Recommendation Report for Planning Permission for Works or Extension to a Dwelling

REF NO: A/60/26/HH

LOCATION: Russetts
High Street
Angmering
BN16 4AE

PROPOSAL: Demolition of existing garage/store and utility room and construction on the same footprint of a guest room and utility room. This application may affect the character and appearance of the Angmering Conservation Area and may affect the setting of a listed building.

12106.05A

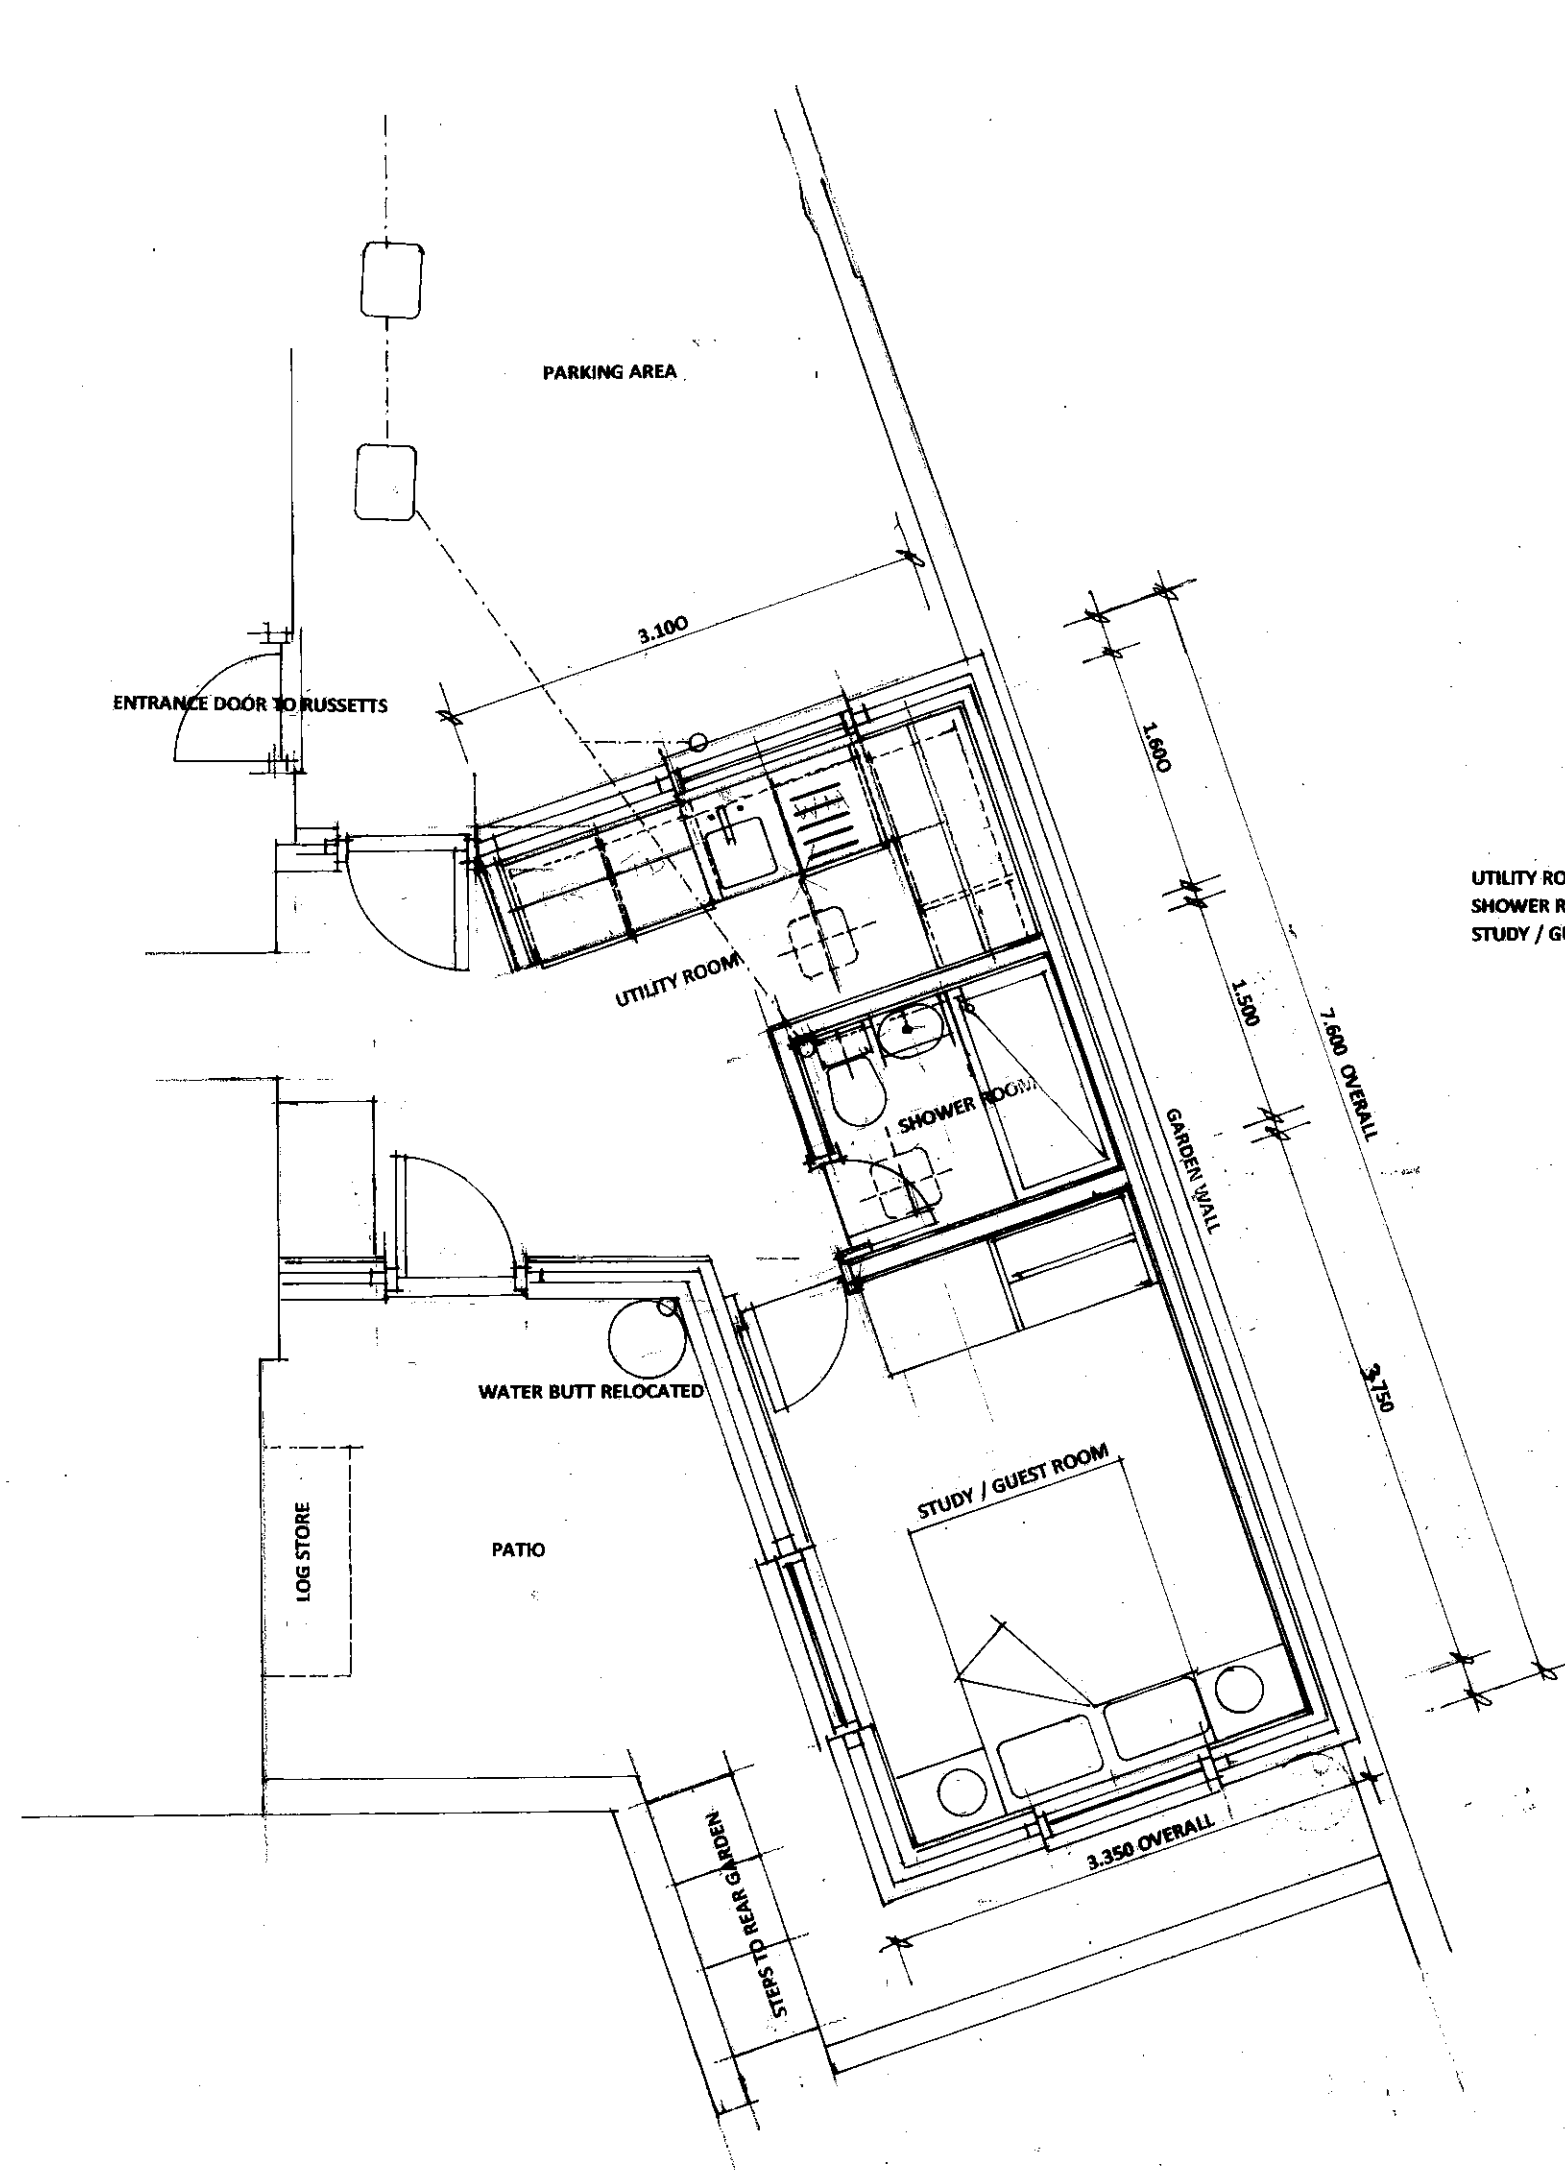
While the proposal would include the conversion of the existing garage, it is noted that the garage is not of an adequate size to accommodate a vehicle in accordance with the Arun Parking Standards (3m by 6m). The parking space to the front would be retained as part of the proposed development. As the garage does not currently contribute to on-site parking provision serving the host dwelling, the proposal would not result in a loss of on-site parking provision and is acceptable in accordance with the Arun

12106.06A

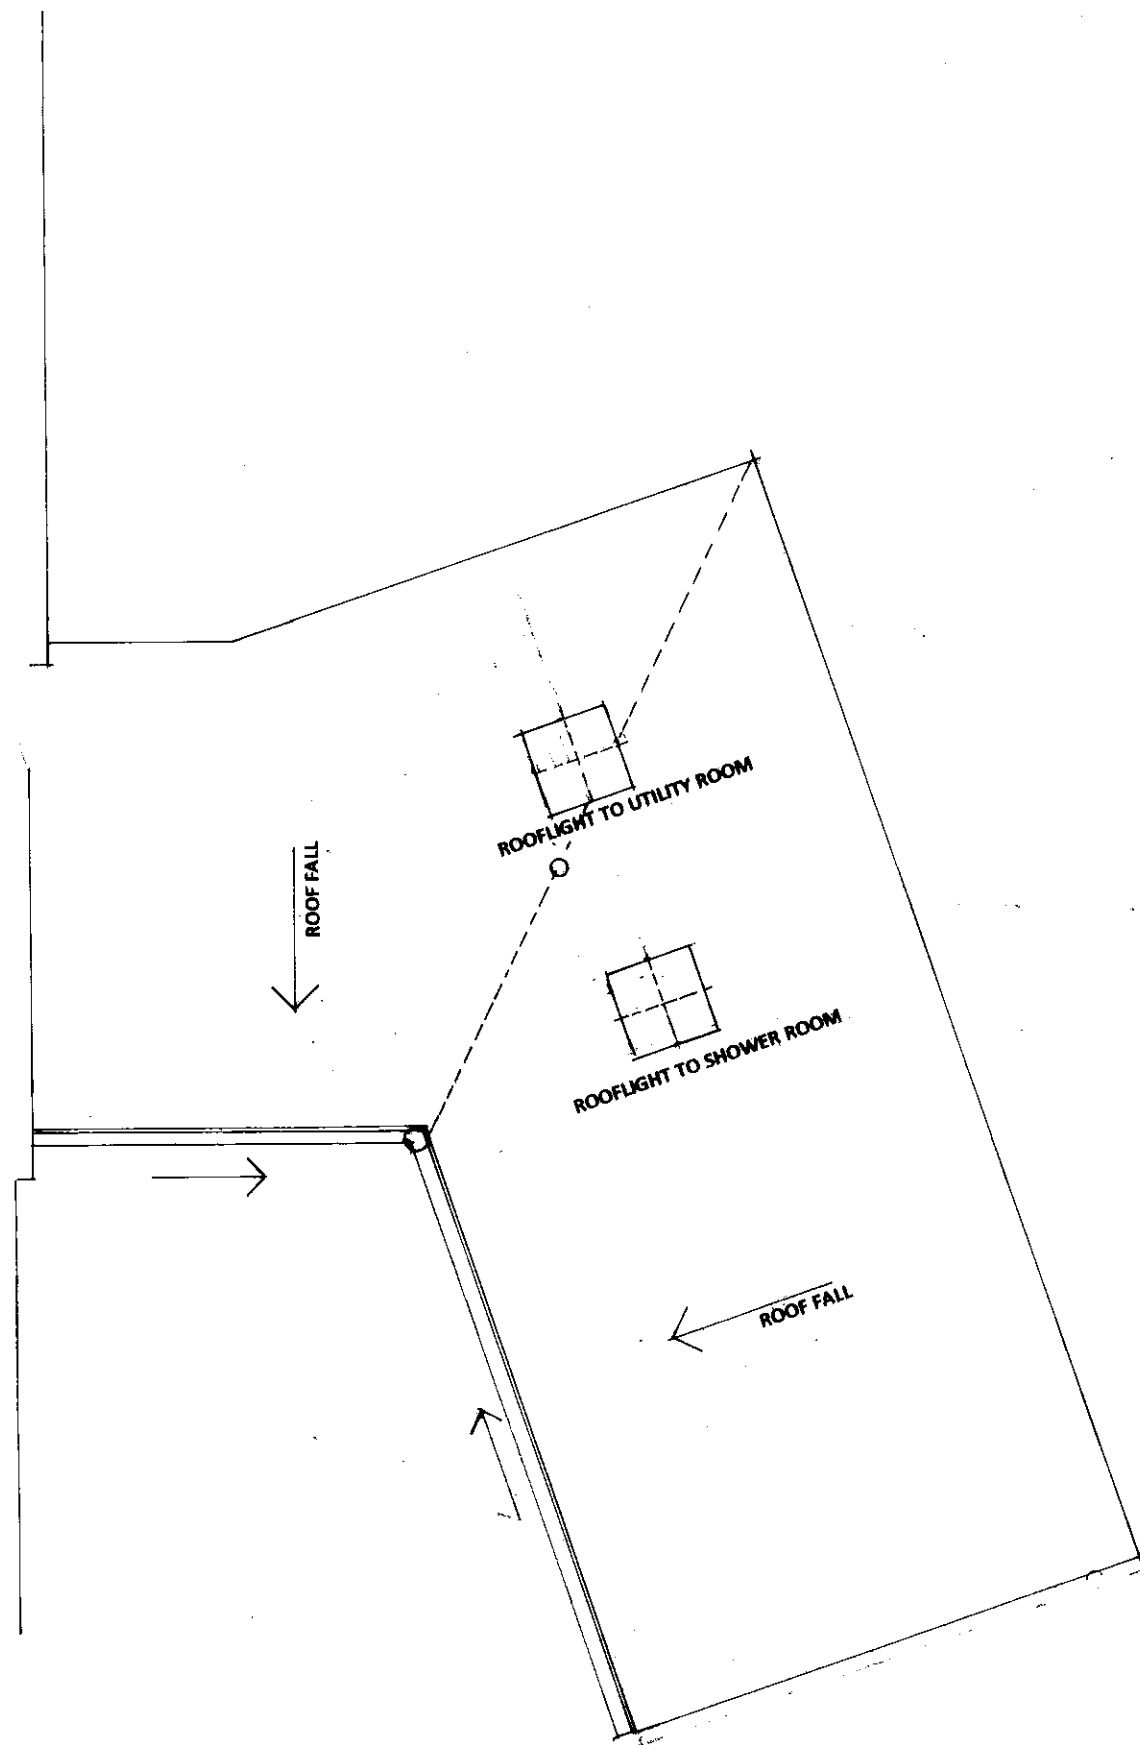
Two rooflights are proposed within the flat roof. The rooflights would accord with Part M of the Arun Design Guide (ADG), as they would maintain the privacy of neighbouring properties and would be used discreetly.

Fenestration to the rear would replace the previous openings and would not introduce significantly different views from those previously achieved. The two rooflights within the flat roof would serve ground floor accommodation and would not result in any overlooking impact.

12106.08A

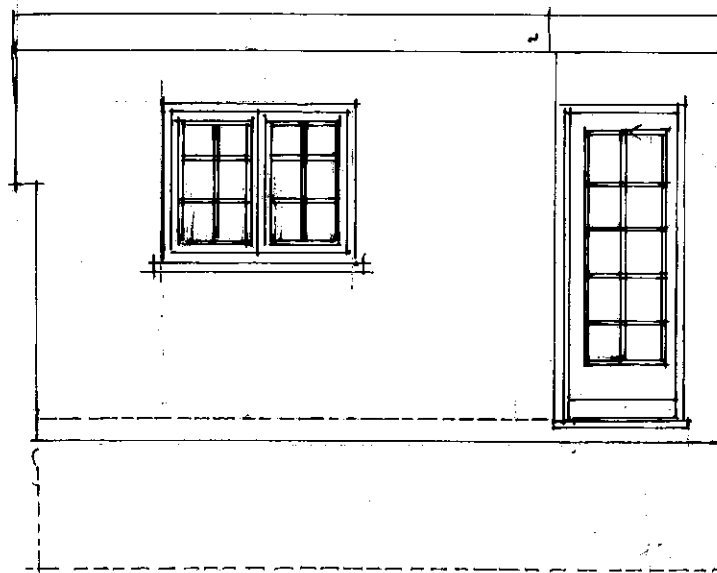
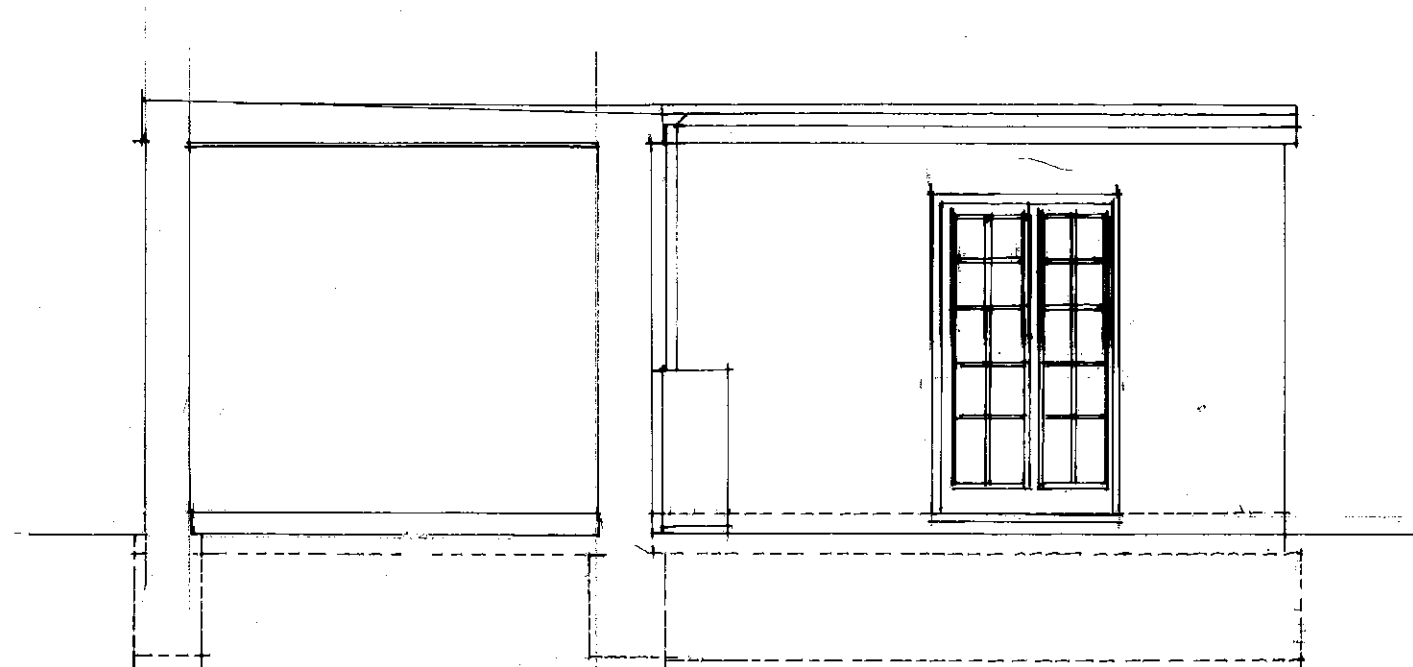
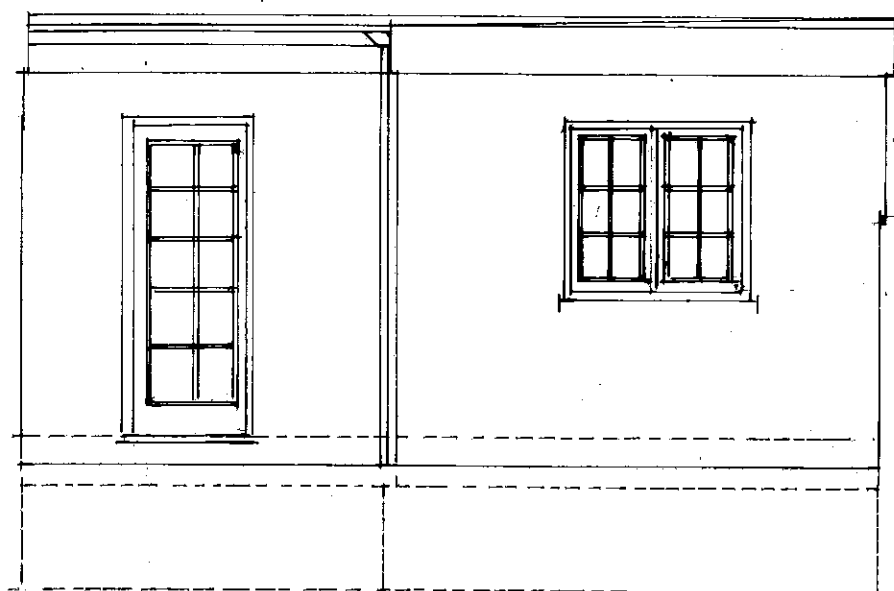
Following the demolition of the existing structure, a replacement extension with the same L-shaped footprint is proposed. To the front elevation, a window would replace the existing garage door. While the footprint would remain the same, the height of the flat roof structure would increase to 2.9m, compared with the existing height of 2.6m. The increase in height is minimal and is acceptable in terms of visual amenity.

Hardwood doors and windows are proposed, in keeping with the materiality of the Conservation Area. Walls would be finished with render to match the existing. Furthermore, the extension would be set back 7.5m from the boundary with the highway and would have limited visibility within the street scene. As such, the works would have a neutral impact on the character of the Conservation Area.
